**Consultation Response from KC,
Lead Local Flood Authority**

2021/94380 Thor Cottage, 12, Thirstin Road, Honley, Holmfirth, HD9 6JG

Erection of first floor extension (within a Conservation Area)

Date Responded: 1st March 2022

Drawing Title:
Location Plan and Site Layout Plans

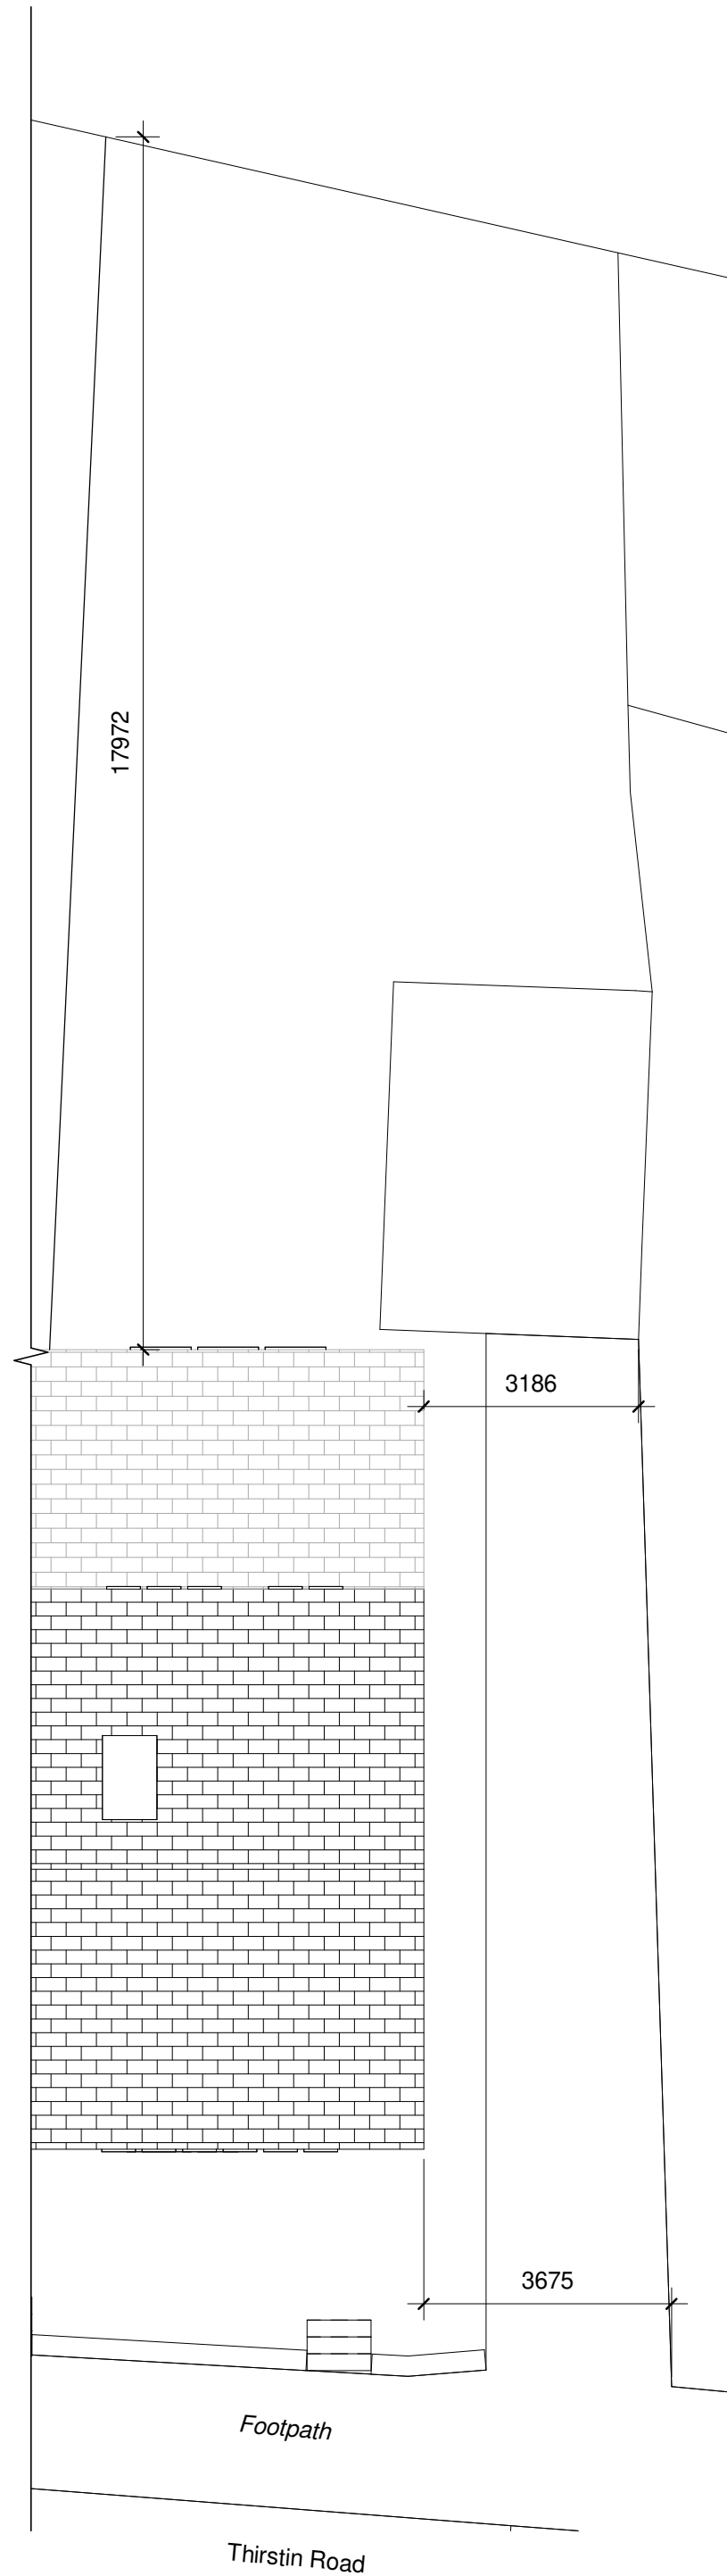
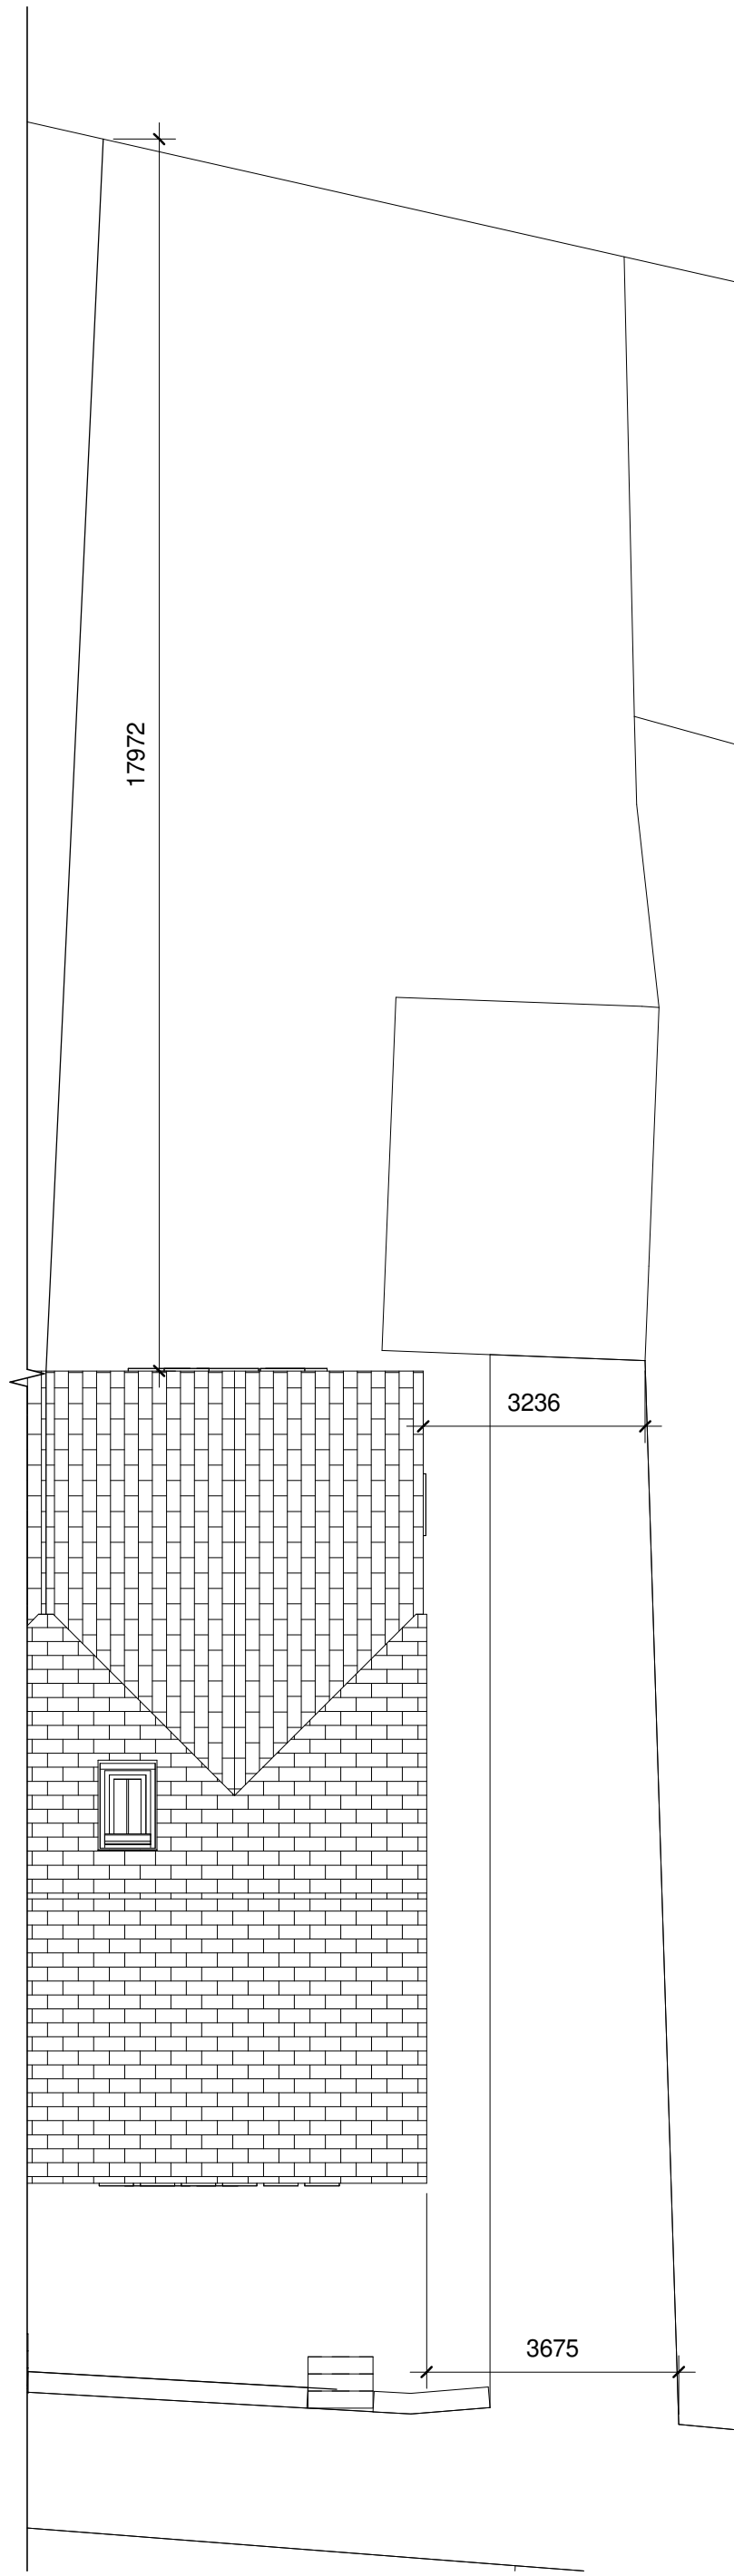
As the culvert in question is already built over by the previous extension works, this development of an extension at first floor level poses no additional risk in terms of location. There has been an attempt to camera the condition of the culvert but this failed due to water flow.

There is space for a future diversion to the rear of the properties should the culvert collapse at any point. As the condition is unknown there is a risk if it is in poor condition and in need of repair and renewal.

We strongly suggest therefore that the foundations are exposed and viewed by our building inspectorate to determine whether any risk is identified in the 'lack of protection' to the culvert, i.e. lintel protection and a class S bed and surround to the pipes, prior to commencing works.
